Development Facilitation Team (DFT) – Review Comments

Project No: PR-2021-005862 Date: 7/02/2025 Agenda Item: #10 Zone Atlas Page (M-08, N-08)

Request: Proposed 102 lot layout

Application For: PA-2025-00183 – SKETCH

CITY OF ALBUQUERQUE DEPARTMENT OF MUNICIPAL DEVELOPMENT ENGINEERING DIVISION	
	EL RANCHO GRANDE UNIT 18 OVERALL GRADING PLAN	
	DESIGN REVIEW COMMITTEE	CITY ENGINEER APPROVAL
CONCEPTUAL NOT FOR CONSTRUCTION		ZONE MAP NO. _____
		CITY PROJECT NO. _____
		SHEET NO. 4

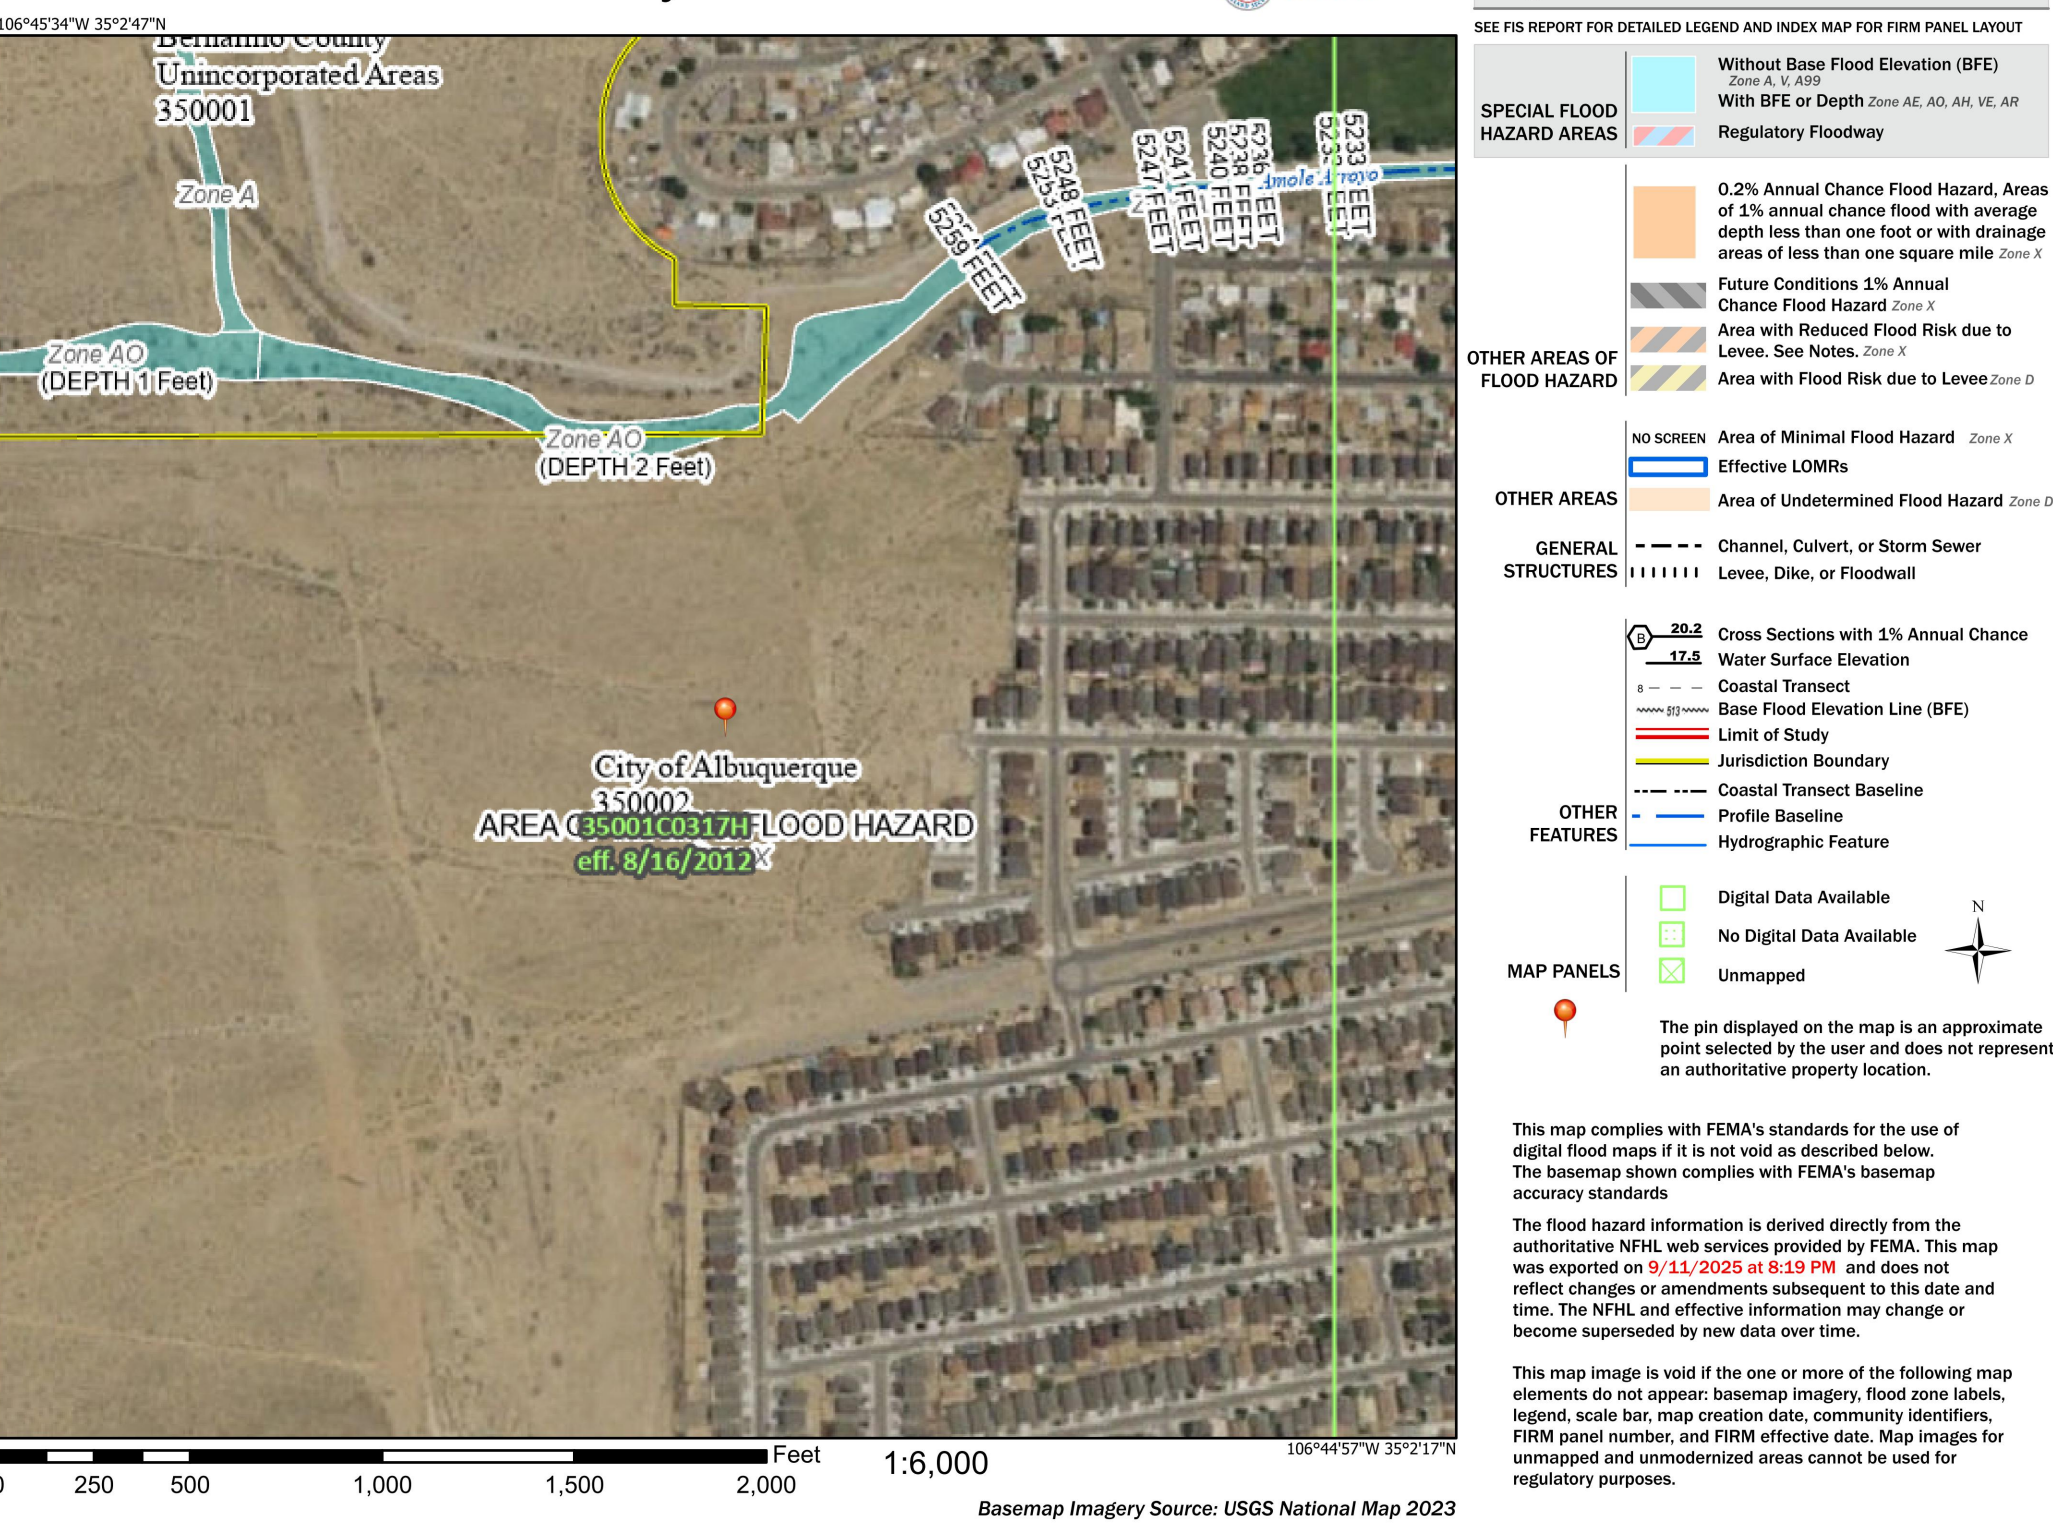
- Hydrology will need an approved Grading and Drainage Plan prior to approval of Preliminary Plat.
- Hydrology will also need a Drainage Study showing downstream capacity.

CITY OF ALBUQUERQUE DEPARTMENT OF MUNICIPAL DEVELOPMENT ENGINEERING DIVISION	
	EL RANCHO GRANDE UNIT 18 ROAD CROSS SECTIONS	
	DESIGN REVIEW COMMITTEE	CITY ENGINEER APPROVAL
		ZONE MAP NO.
		CITY PROJECT NO.
		SHEET NO. 14

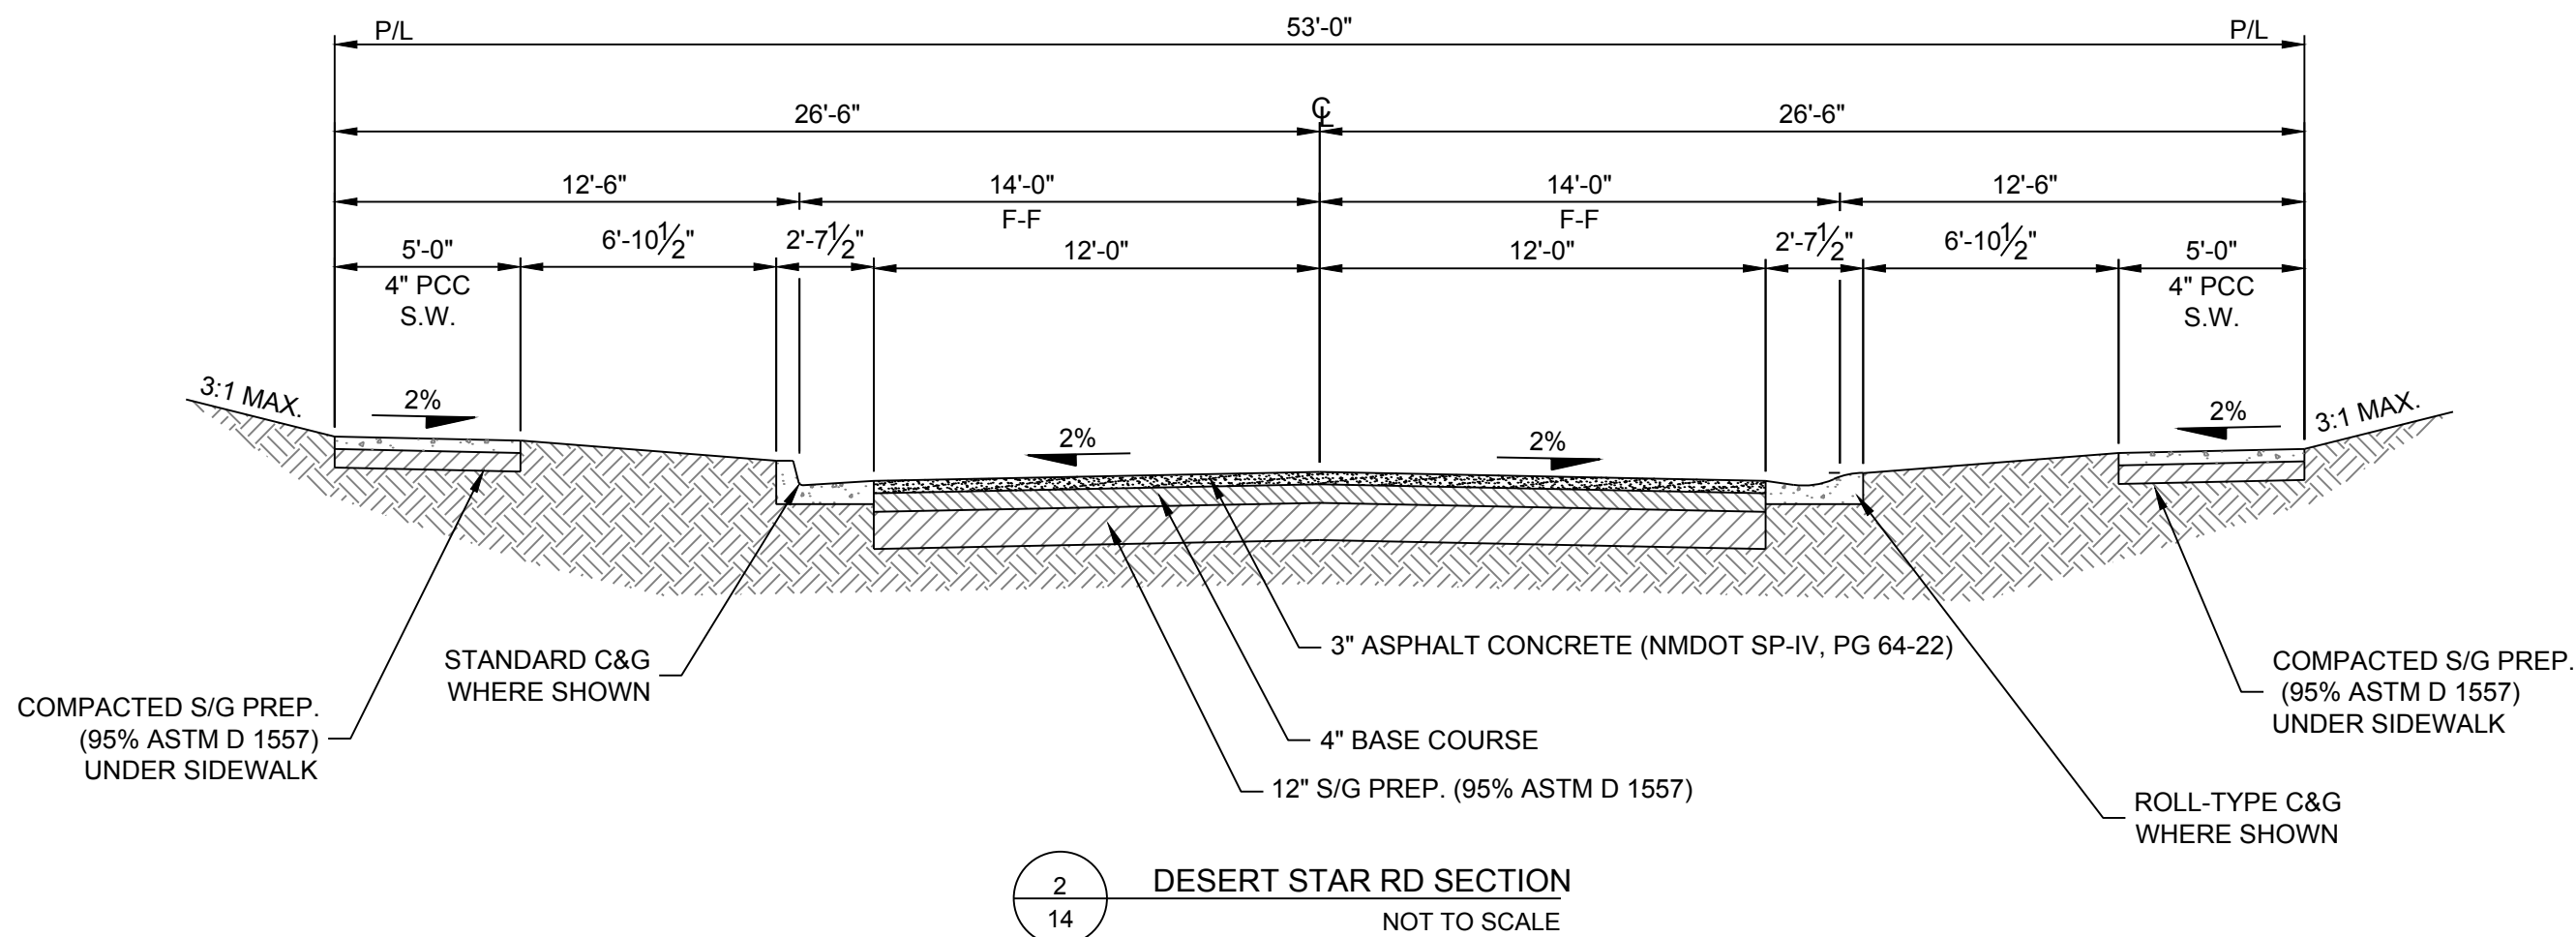
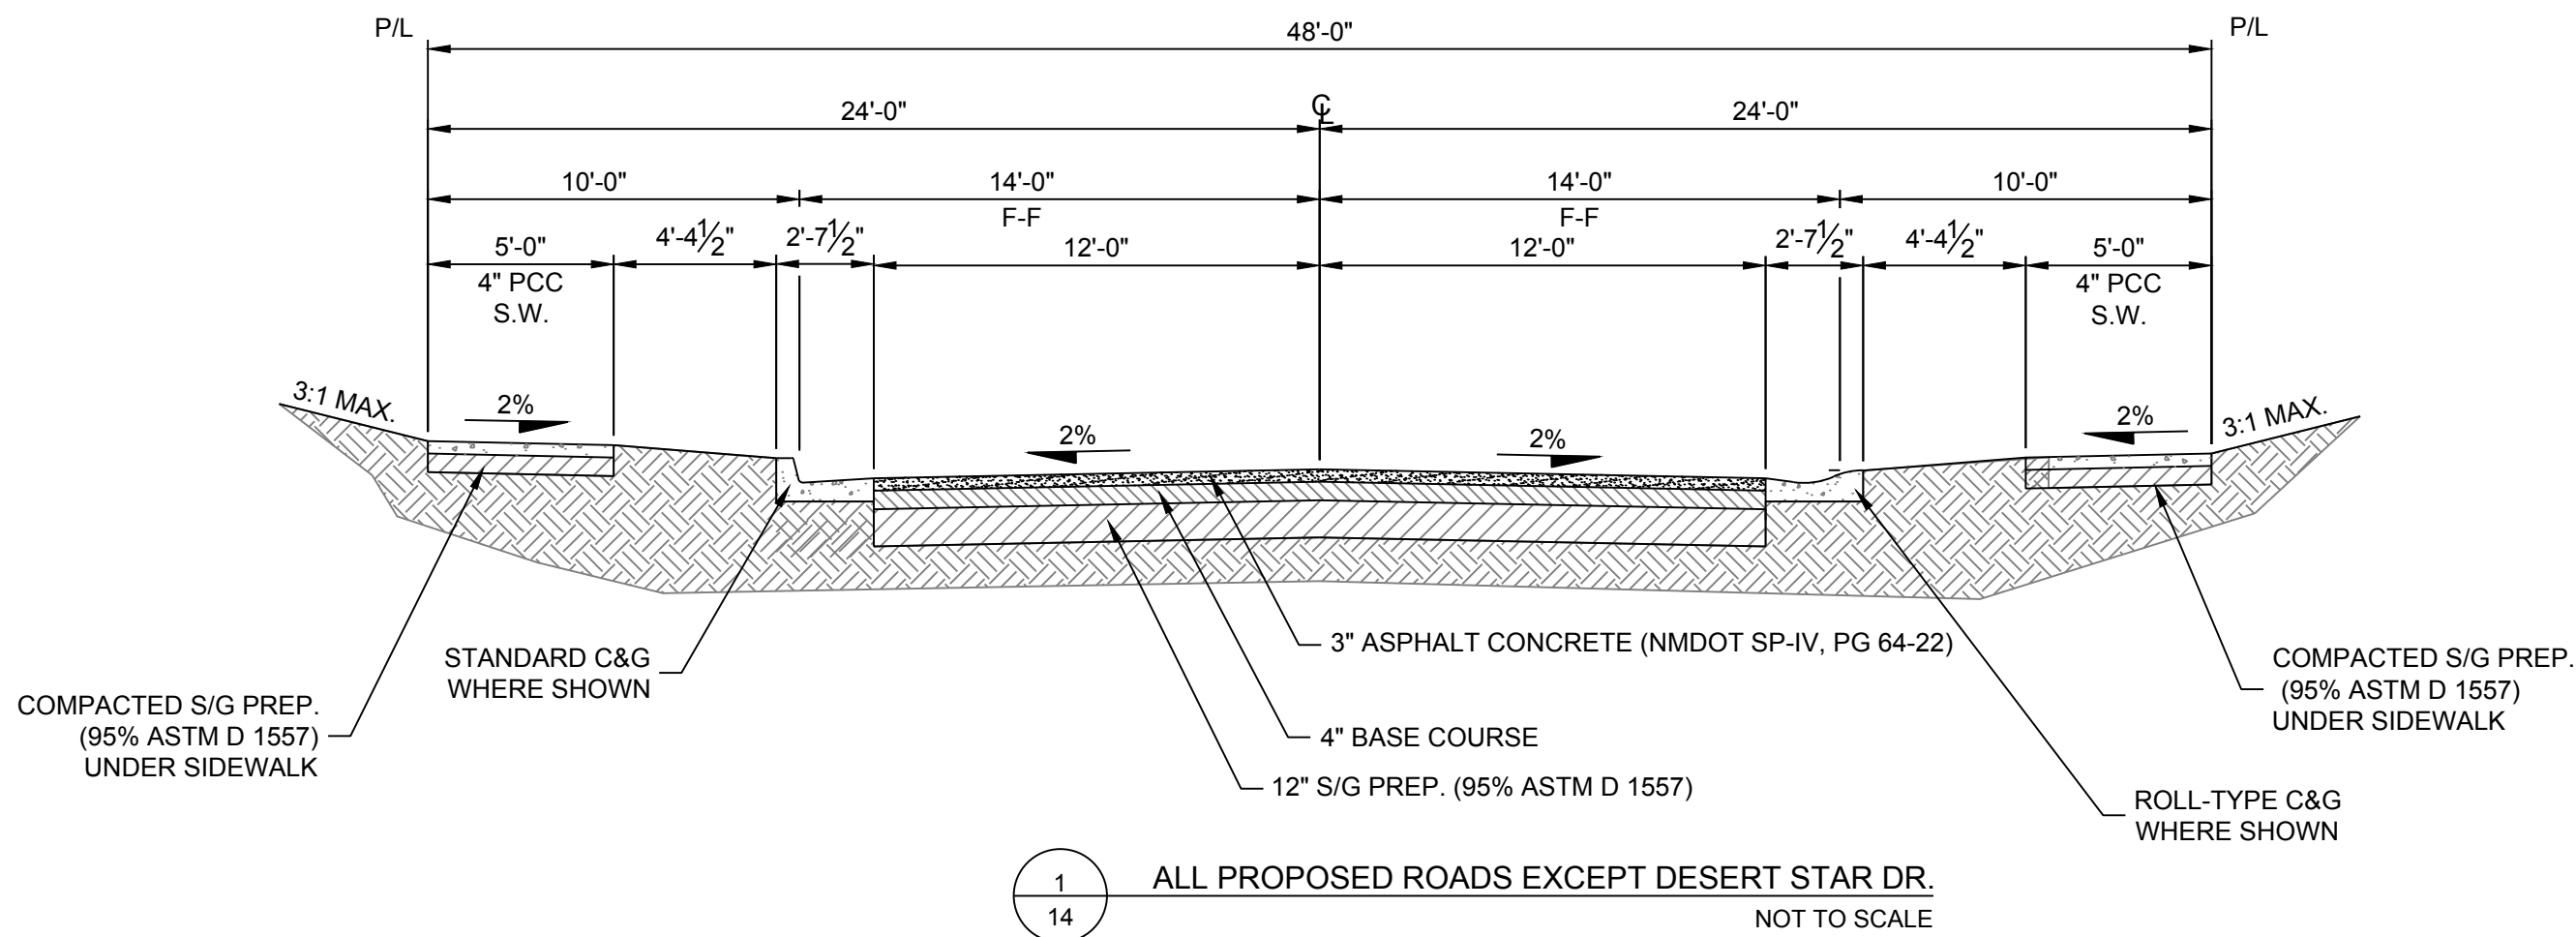
1. Gibson will need to be constructed along the frontage of the property including curb, gutter and sidewalk. Gibson is a Principal Arterial and requires 6' sidewalk with a 5' to 6' landscape buffer.
2. All internal roads will need to be built to local road standards and will require 5' sidewalks with 4' to 6' landscape buffers.
3. Prior to site plan please provide dimension of roadways and sidewalks. Also, a Traffic Scoping Form will need to be submitted to determine if a traffic study will be required.
